Consultation Response from KC, Conservation and Design

2020/91896 Pentlands, New Mill Road, Holmfirth, HD9 7LN

Demolition of existing dwelling and erection of 25 dwellings with associated access and external works

REVISED following receipt of amended plans

PROJECT TITLE		NEW MILL ROAD	
DRAWING TITLE		PROPOSED SITE PLAN	
SCALE	DRAWN	CHECKED	PROJECT REFERENCE
1:200	JH	JH	ODS-19-77
PAPER SIZE	DWG NUMBER	DATE	REVISION
A1	(20)001	22/1/20	J
CLIENT		PRIESTROYD CONSTRUCTION

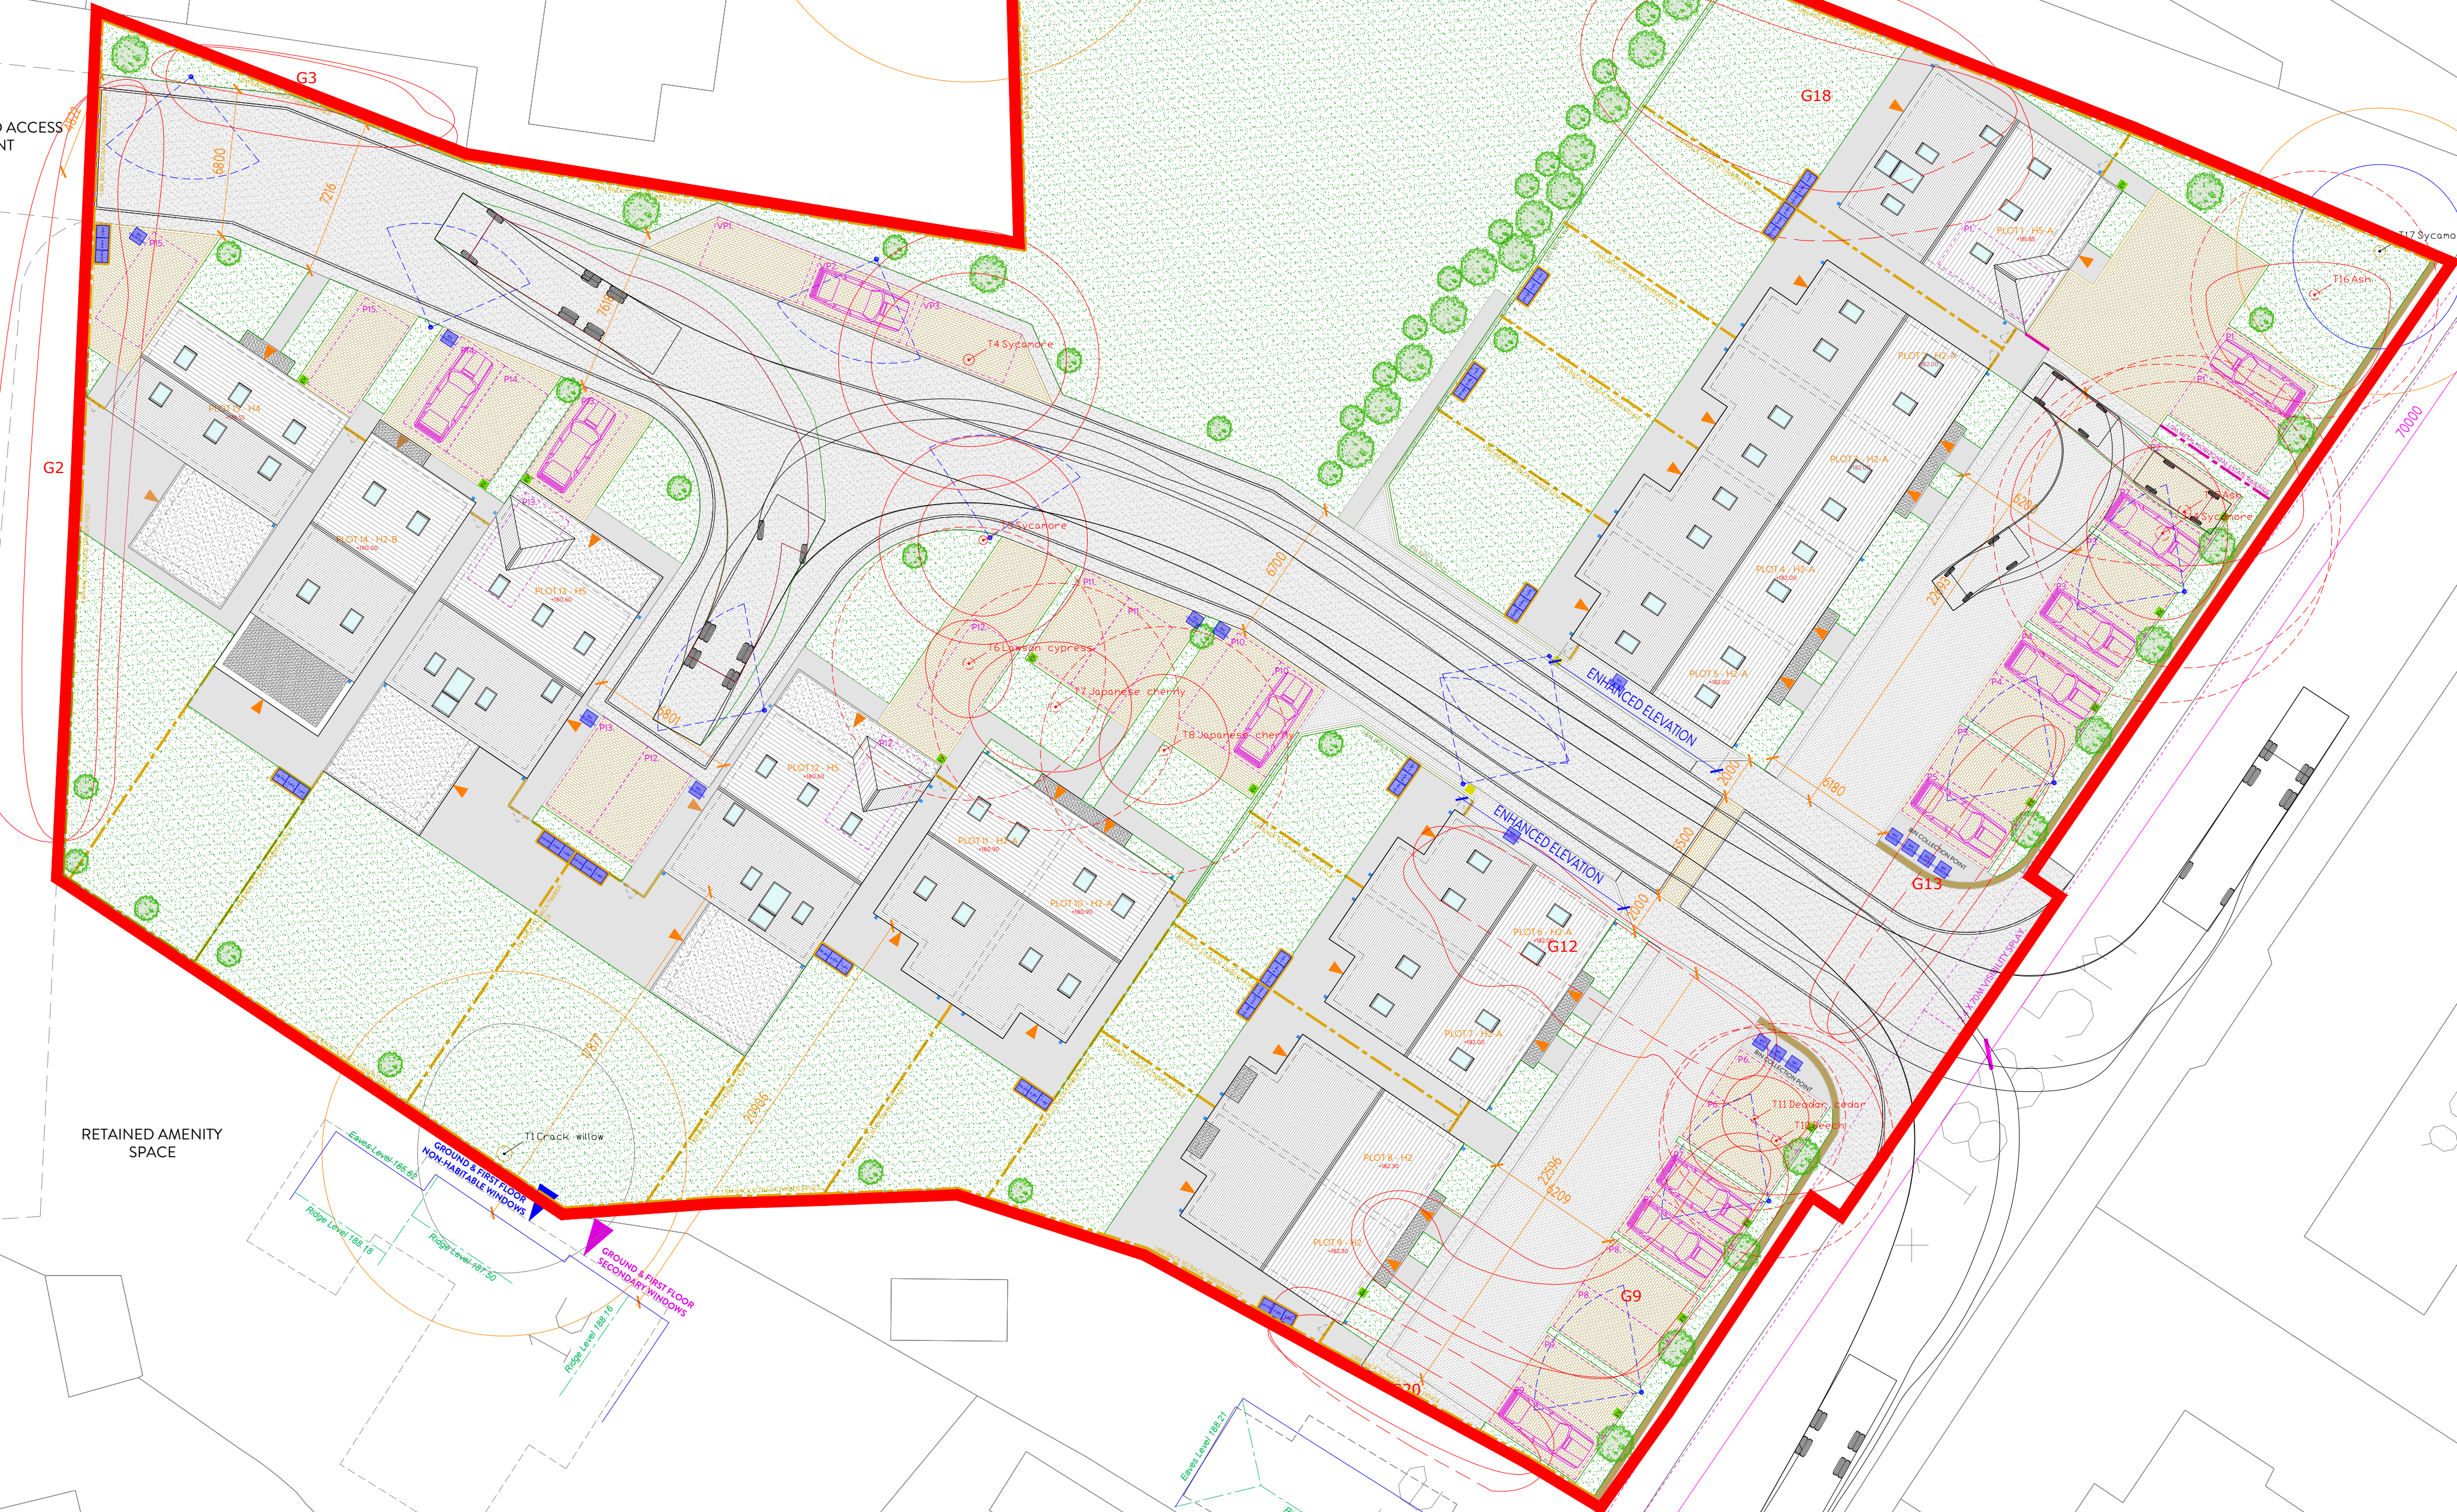
With regards to design, the revised layout is significantly improved with areas of parking broken up with landscaping. The development now addresses New Mill Road suitably. The number of house types, roofs forms and the proportion of three storey houses has been reduced, the omission of House Type 1 with its deep plan and back-to-back layout is a significant improvement. The development would therefore be more in keeping with the local townscape.
